CITY OF ALBUQUERQUE PLANNING DEPARTMENT January 21, 2015 DRB Comments

PROJECT # 1004245

APPLICATION # 14-70220/ 70221

RE: Blocks 7 – 9, 12 & 14, PARADISE HEIGHTS UNIT 5

PRELIMINARY PLAT FOR
ANASAZI RIDGE UNIT 3
 WITHIN THE
 TOWN OF ALAMEDA GRANT
 PROJECTED SECTION 3
 TOWNSHIP 11 NORTH, RANGE 2 EAST, NMPM
 CITY OF ALBUQUERQUE
 BERNALILLO COUNTY, NEW MEXICO
 JUNE, 2014

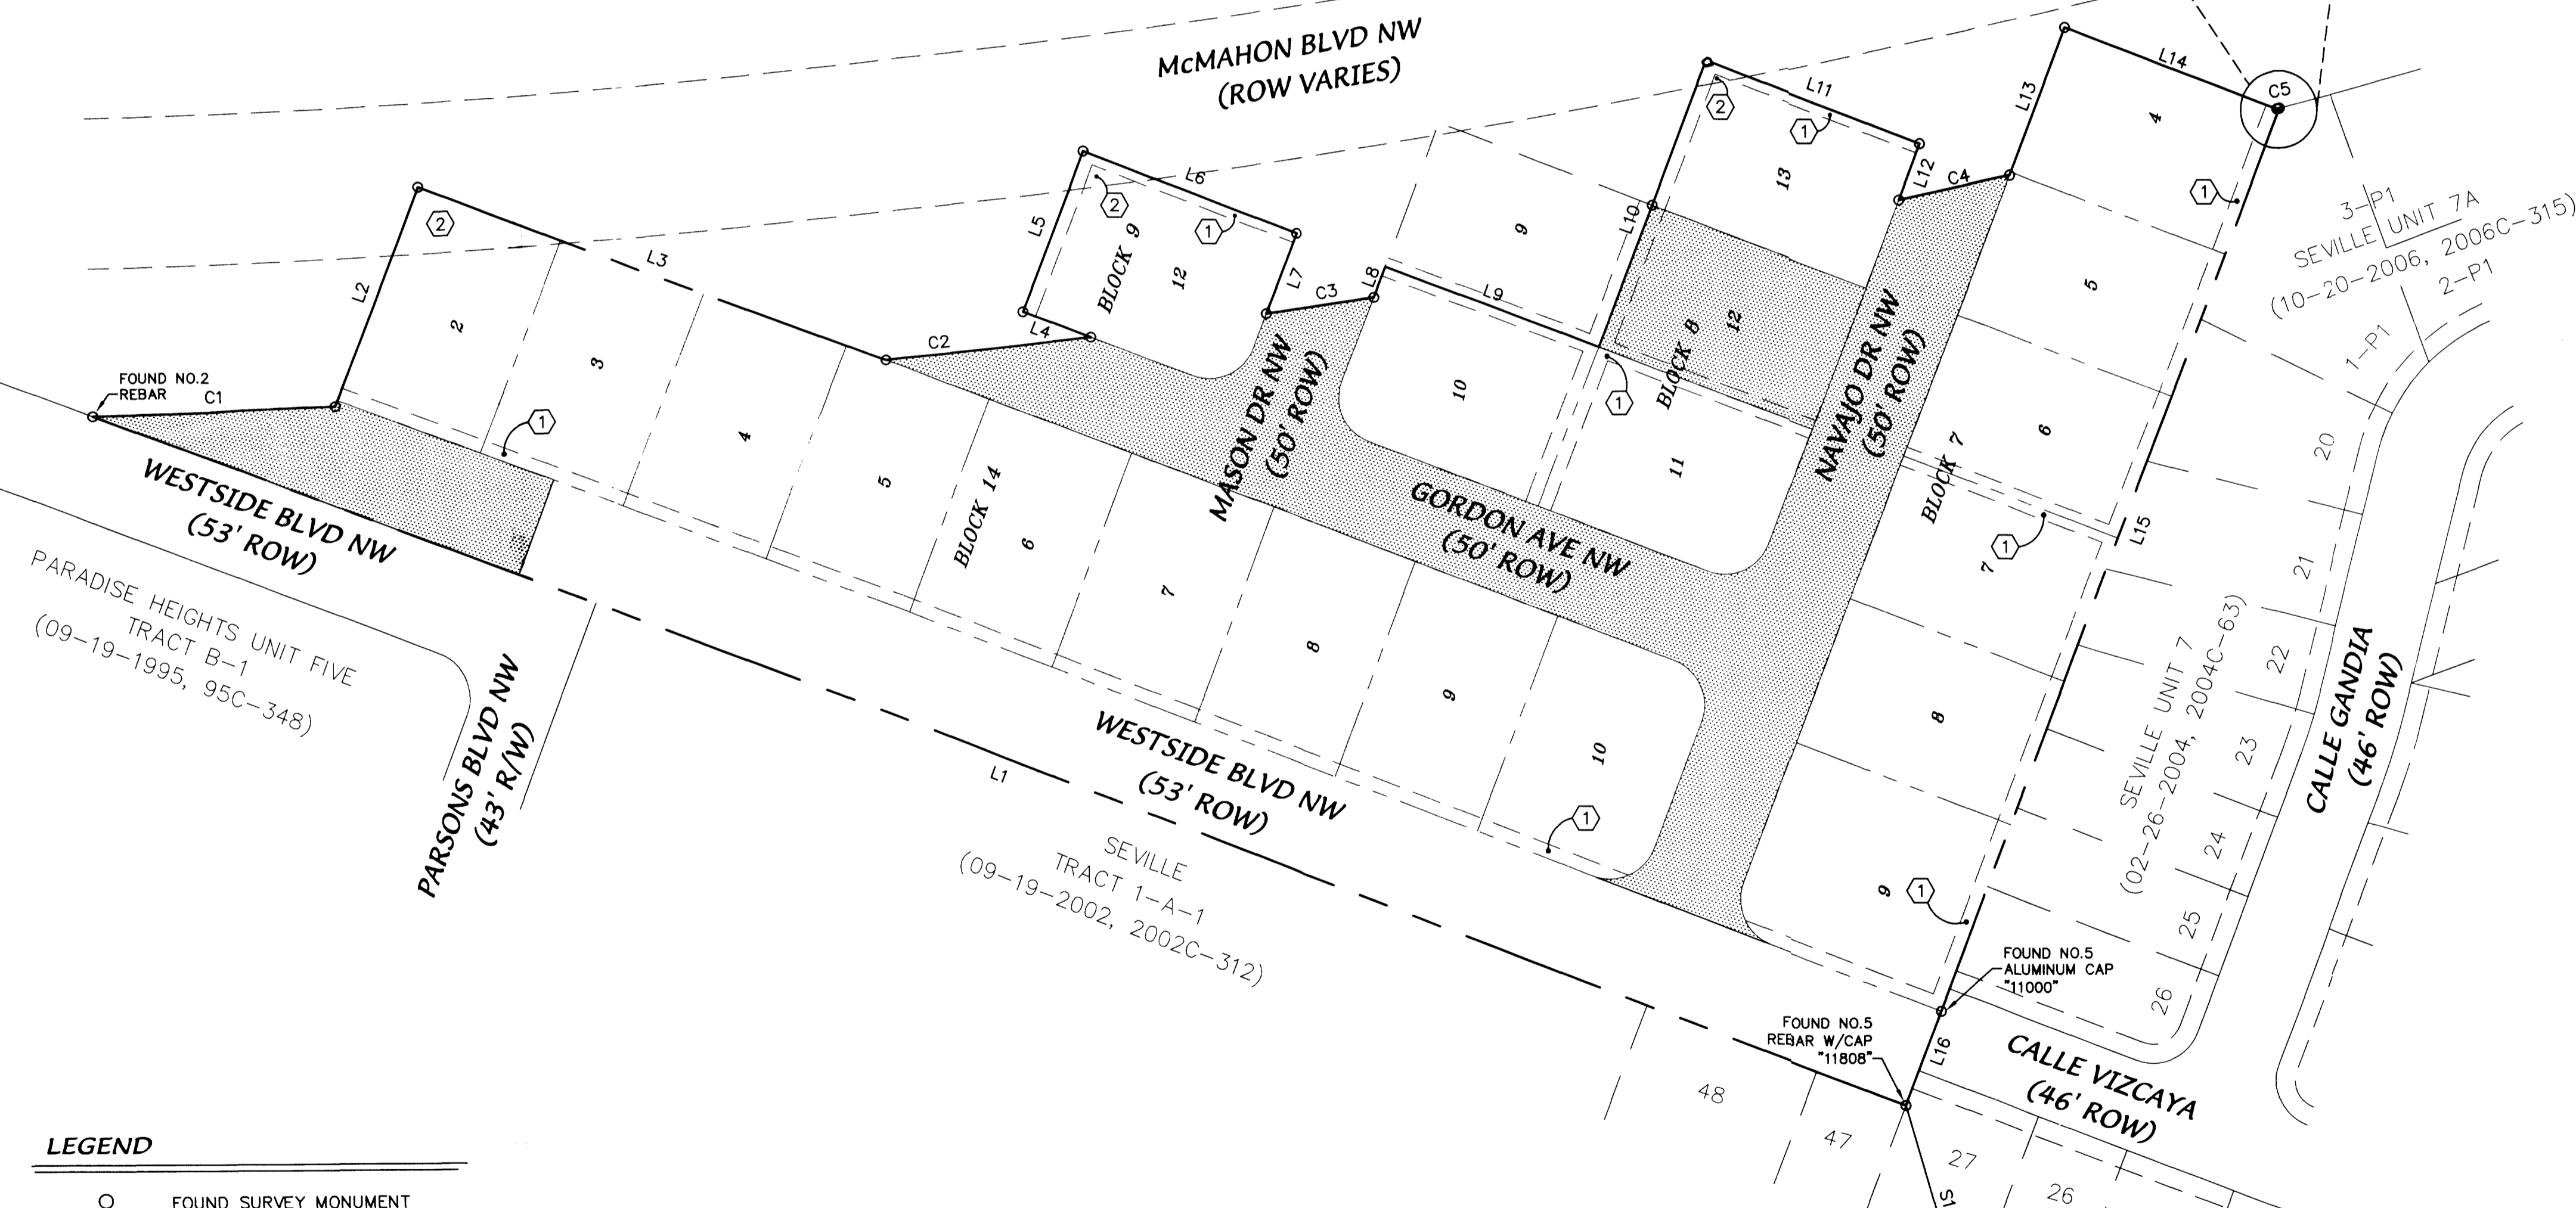
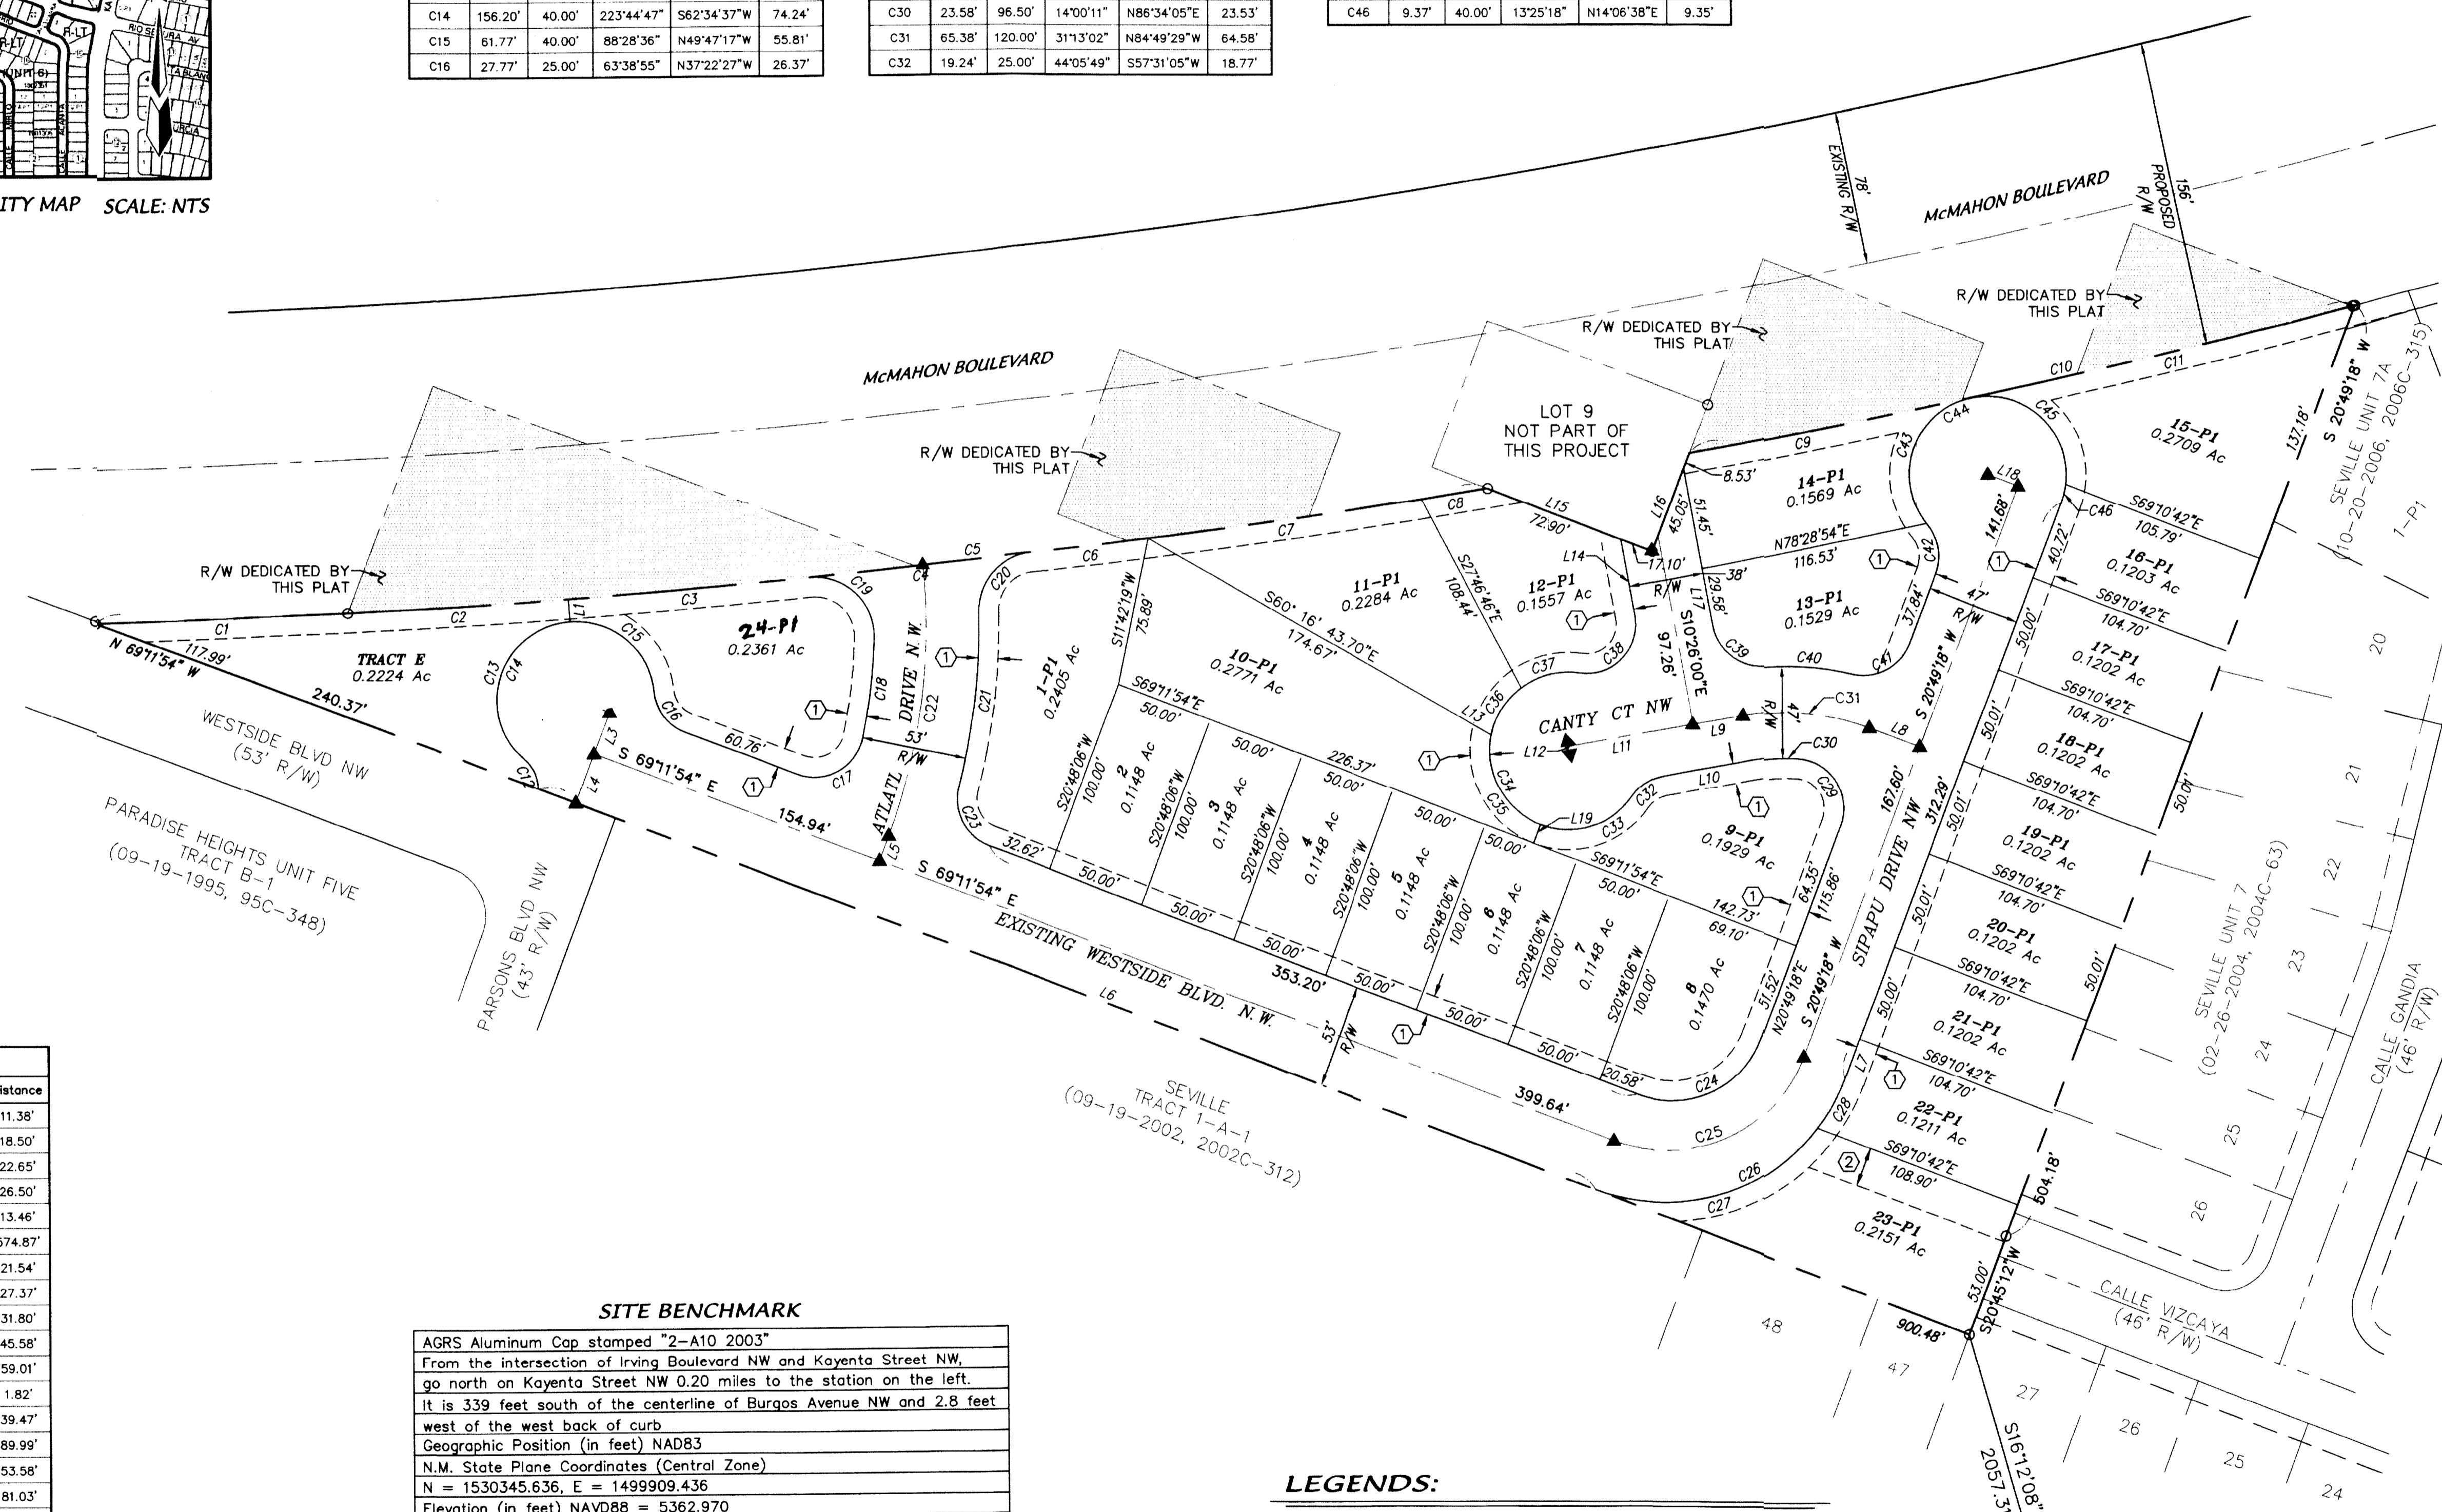
The creation of additional Tracts encumbered by easements is not appropriate given the relatively small number of lots in the proposed subdivision.

Refer to comments from Transportation Development regarding cul de sacs for Sipapu Dr (vs. stub street) and Westside Blvd (vs. utilizing Parsons Blvd for temporary turnaround).

Refer to DRB comments regarding Sidewalk Waiver; a pedestrian connection from Sipapu to McMahon should be shown on Infrastructure List and Grading Plan.
